2024/0847

5 Nelson Avenue, Monk Bretton, Barnsley, S71 2LY

Erection of two storey side extension and single storey rear and front extensions to dwelling

05 NELSON AVENUE, BARNSELEY. S71 2LY
PLANNING - PLANS - EXISTING AND PROPOSED

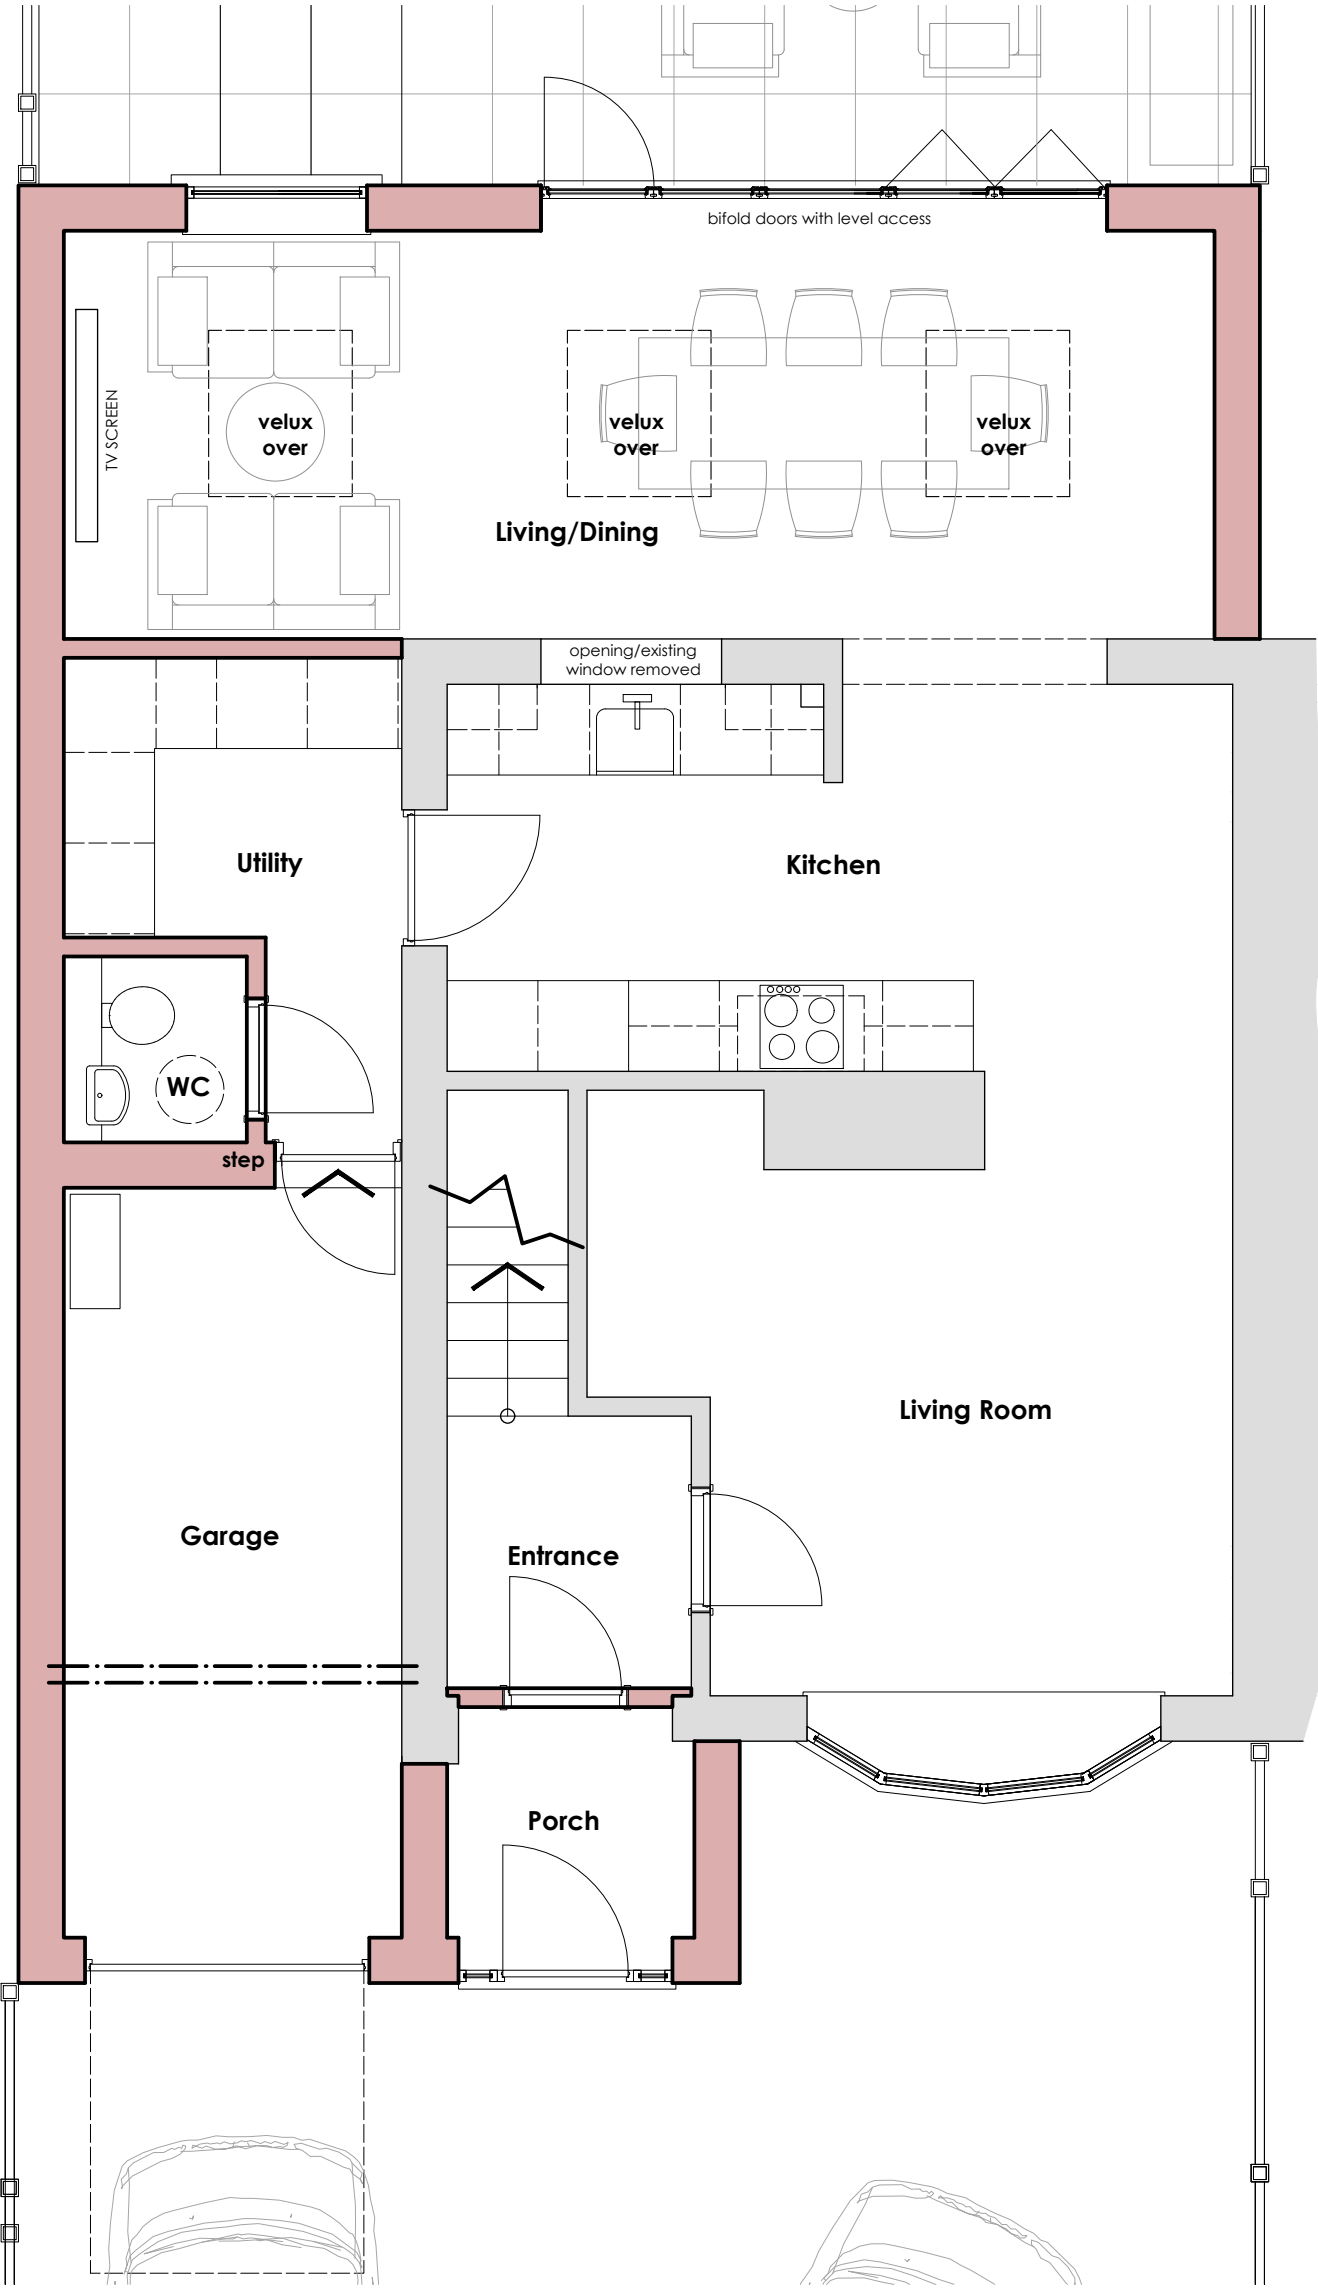
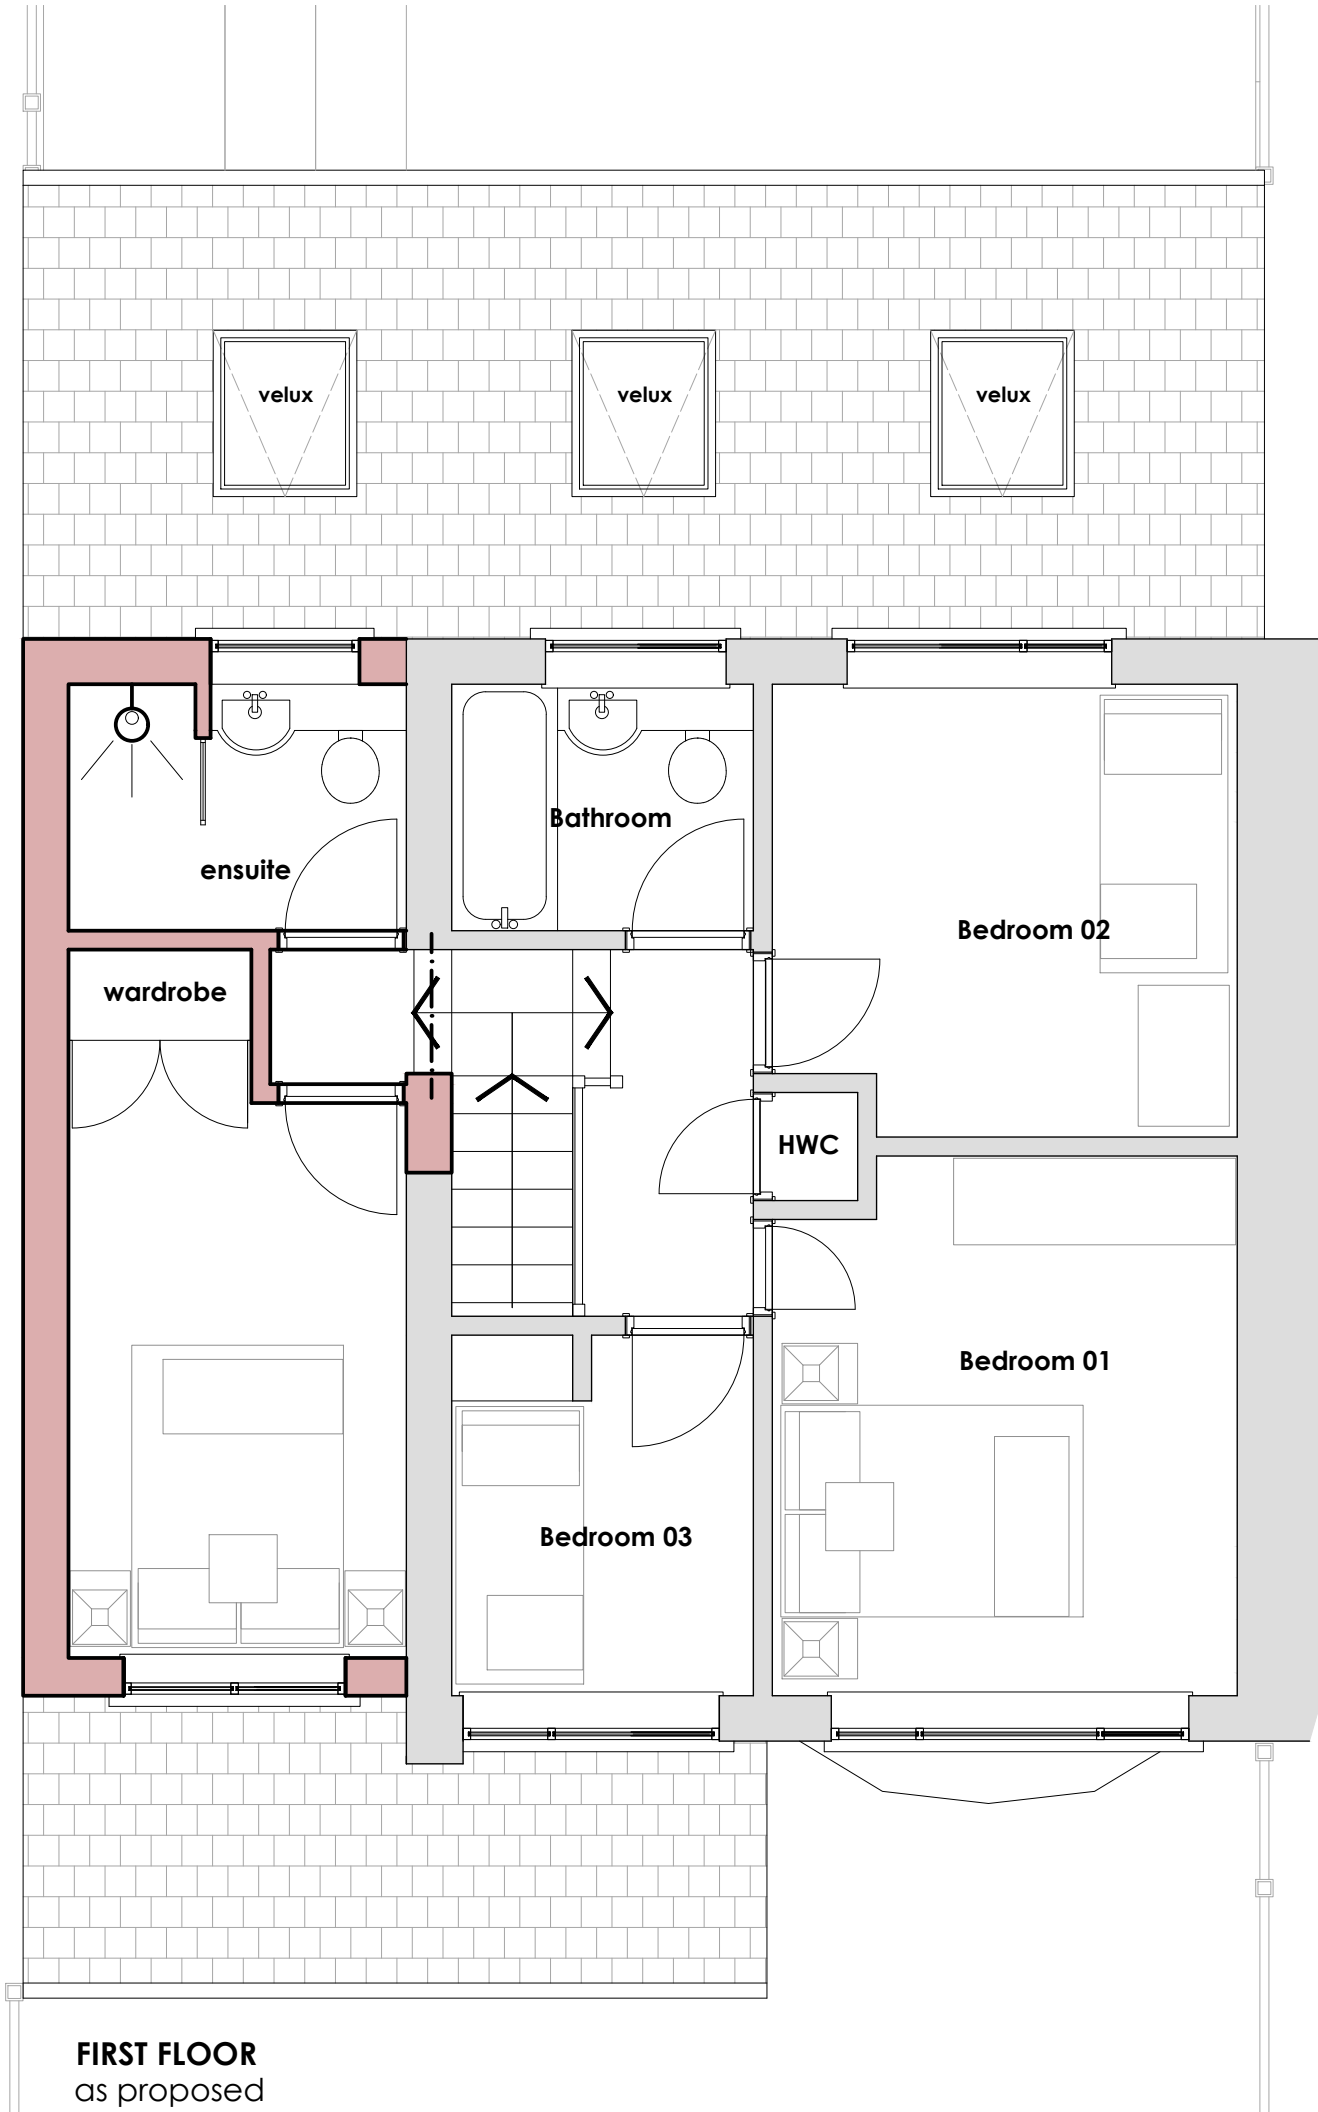
The proposal to extend the front of the garage allows for an increased garage size which could be utilized for the storage of bins. This facility is not currently available to the property. The front extension benefits from a pitched roof element above the garage and porch which breaks up the dominance of the extension to the principal elevation. The proposed garage door and front door are of a similar size to the existing garage door and front door. This allows for the proposal to not dramatically change the character of the street scene. The proposed second storey window to the front of the dwelling matches the size of existing windows on the dwelling.

The proposal would result in an increase in bedroom accommodation of 3 to 4. The site already provides enough parking facilities for 2 or more cars so will not require any additional parking facilities.
